**MetroLink**

## **Additional Errata Relating to Chapter 20**

Document Title: Additional Errata Relating to Chapter 20

Path: \\uonpc-jacobson\dublin\data\GIS\GIS\Maping\Working\EIA\Drawings\20 - Fig 20.6 Land contamination.aprx

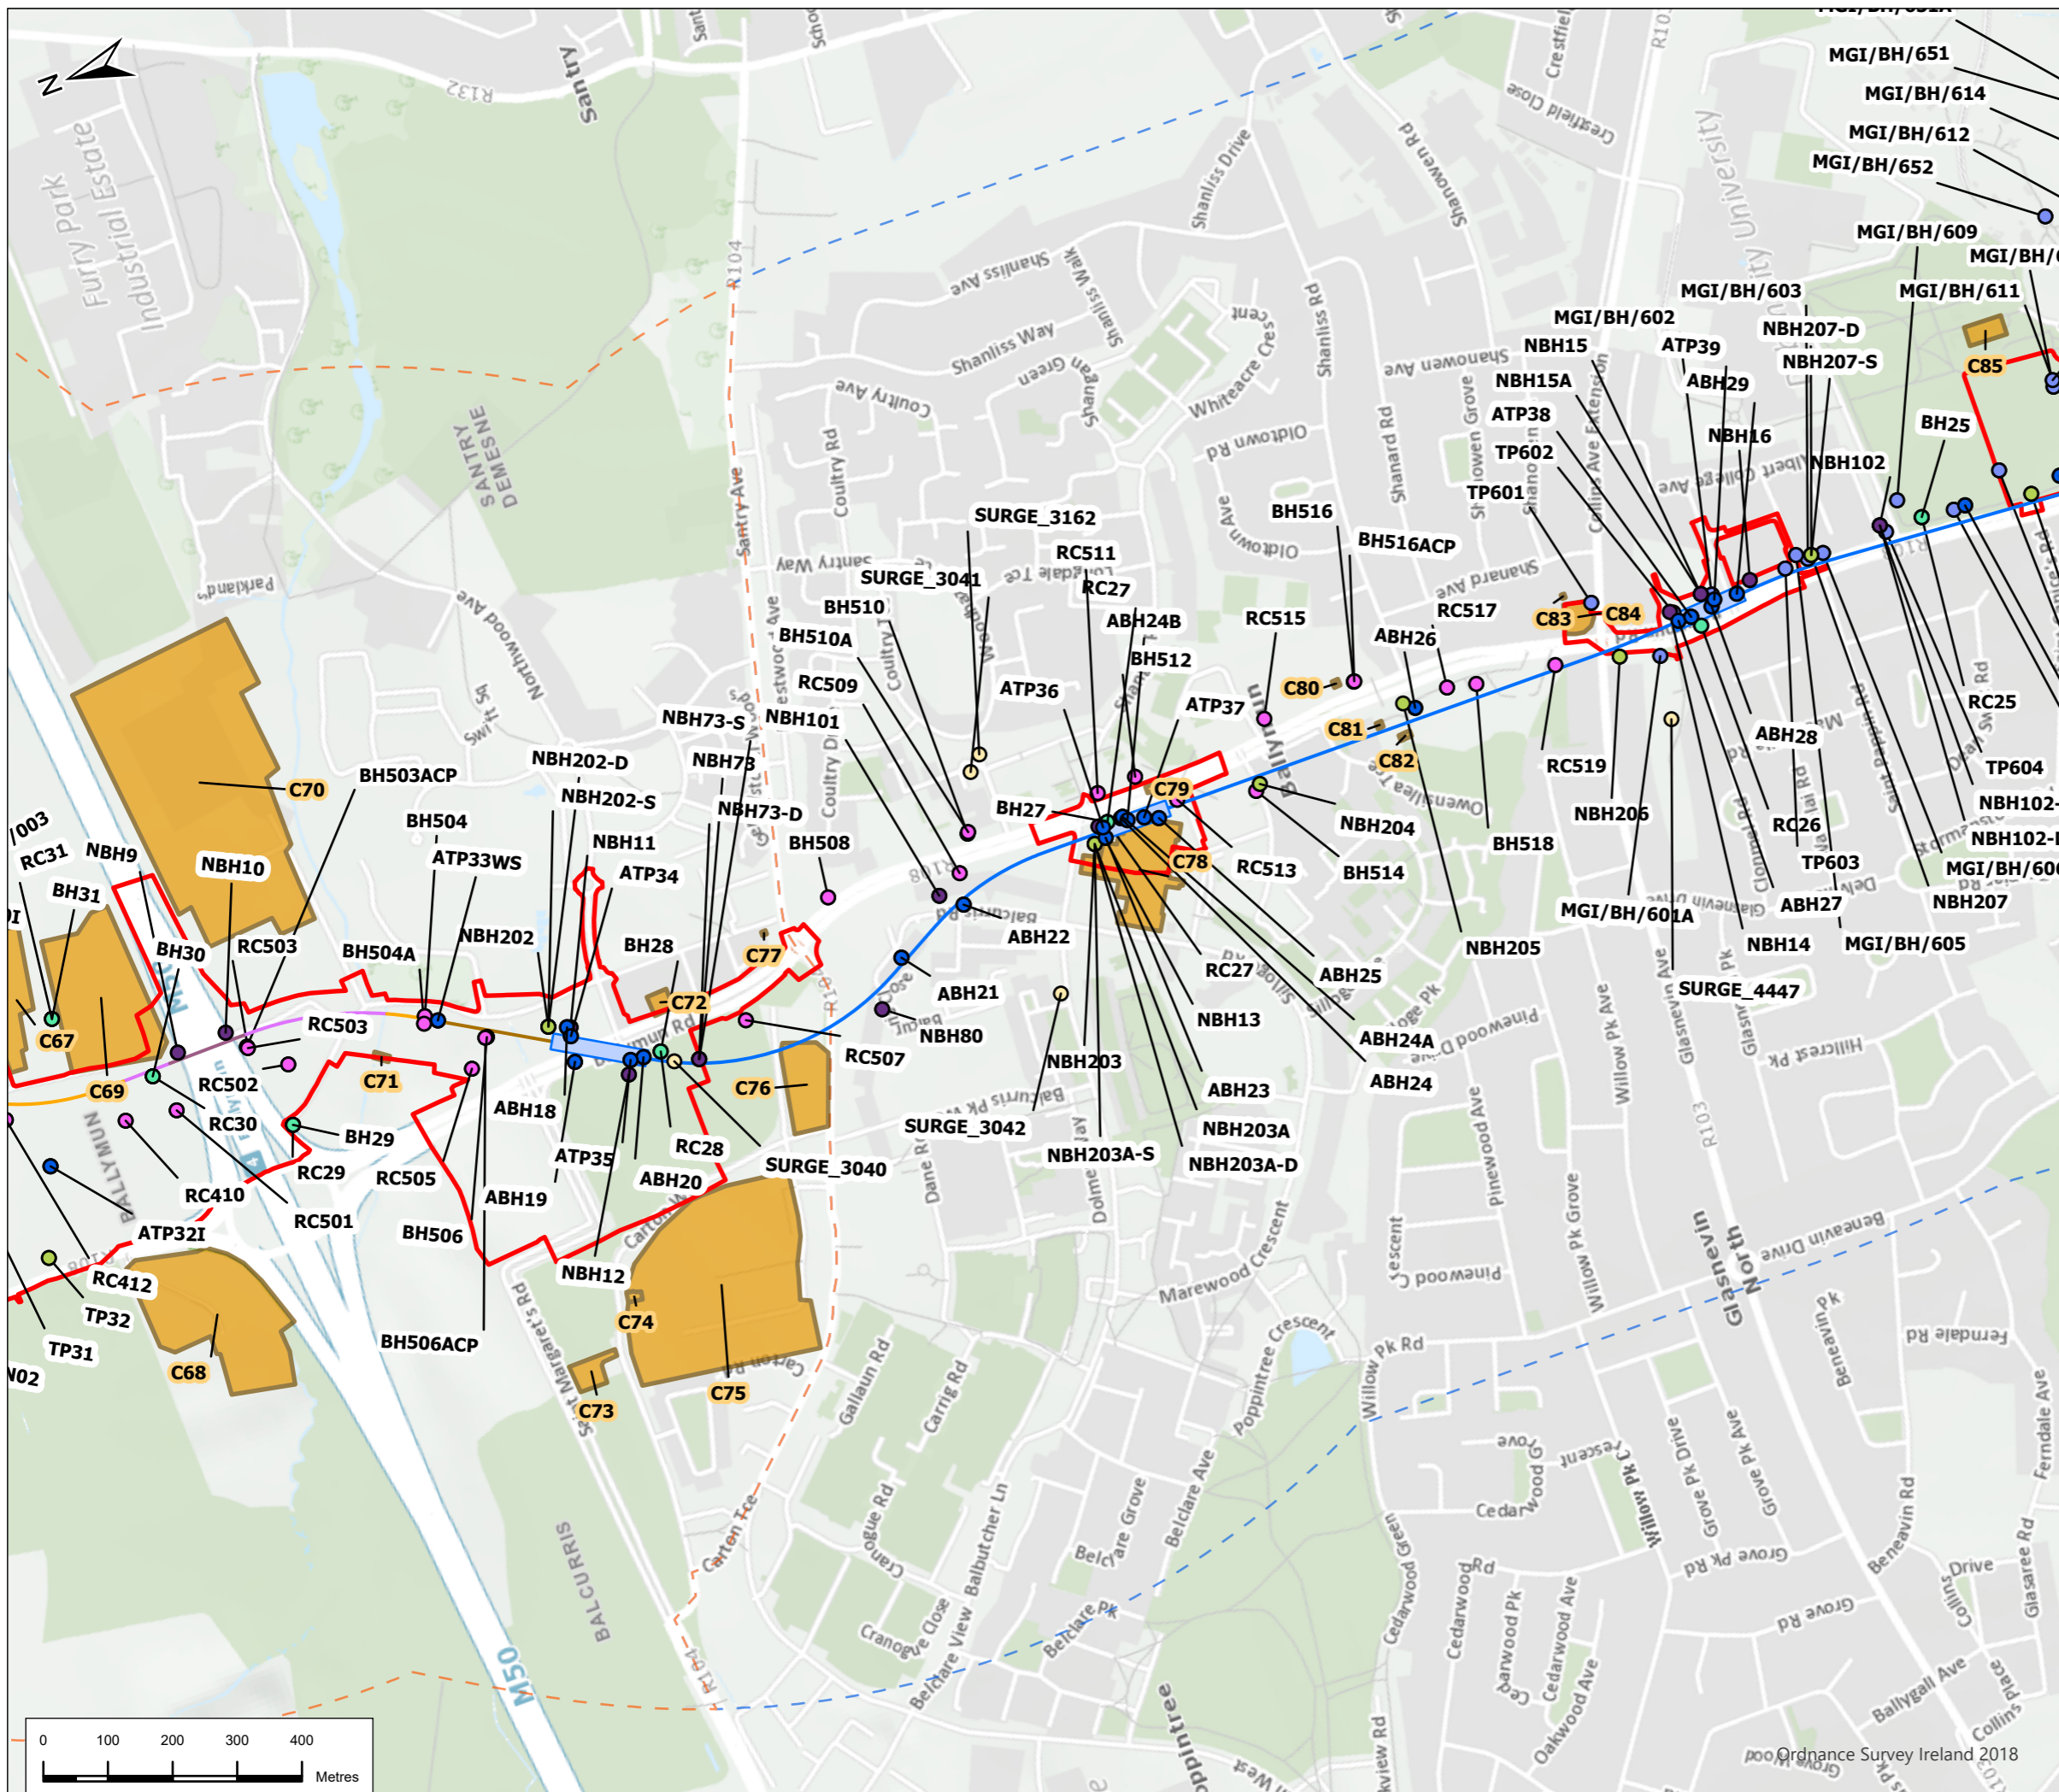
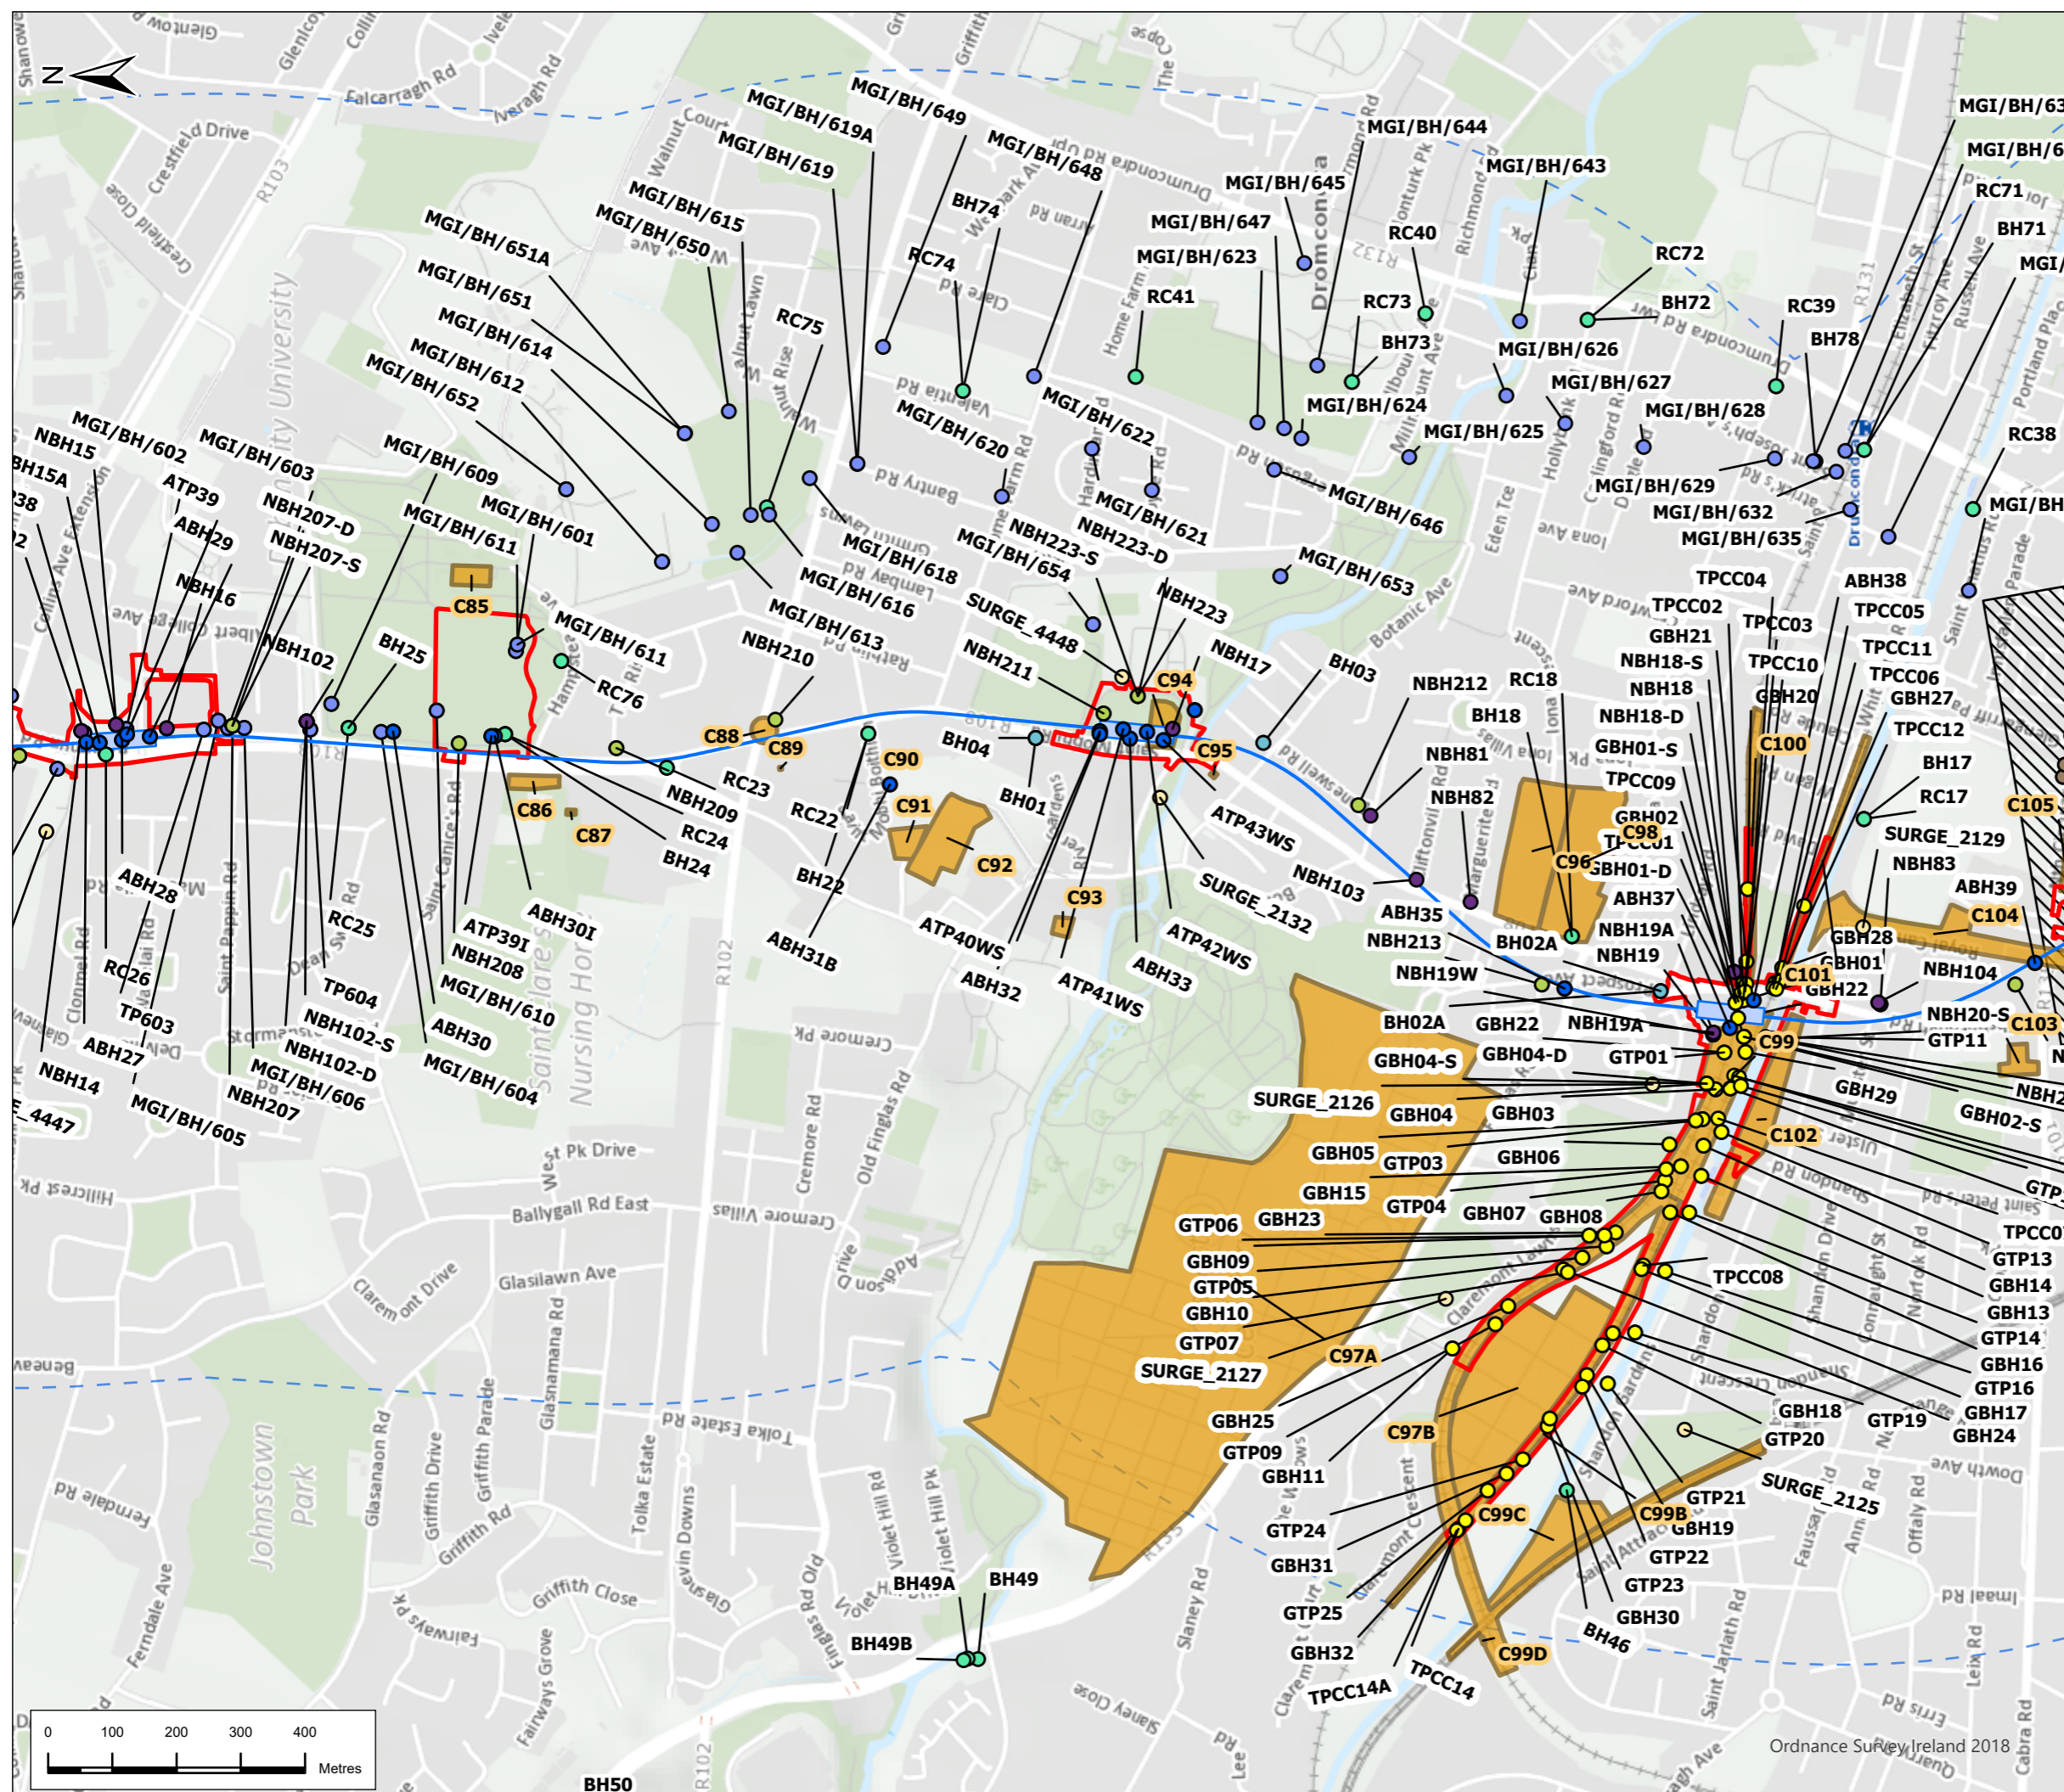
It has become clear during the course of the oral hearing that, in error, borehole locations which appeared in an early drawing of proposed bore hole locations, and which did not form part of the Geotechnical Investigation (GI) scope, were included in error in the chapter presentation as follows:

- Figure 20.6 (Revised version attached)
- Appendix A20.1 (Summary of Supporting Ground Investigation Scope)
- Appendix A20.2 (Summary of Relevant Exploratory Hole Locations and Monitoring data)
- Appendix 20.8 (Appendix A Tables A1 to A4) and Figure 20.6.

Chapter 20 includes summaries of the ground investigation (GI) data used in development of the assessment as detailed above as well as a figure detailing the GI locations. An error has been identified whereby proposed borehole locations which were not actually drilled were included in the summary tables detailed above and Figure 20.6. These borehole locations were not drilled as they were not required. The proposed Phase 1 borehole references included in error are listed in Table 1.

The inclusion of these proposed GI location references was mistaken, and it should be noted that boreholes at these proposed GI locations were not drilled. Consequently, there is no data associated with these proposed locations.
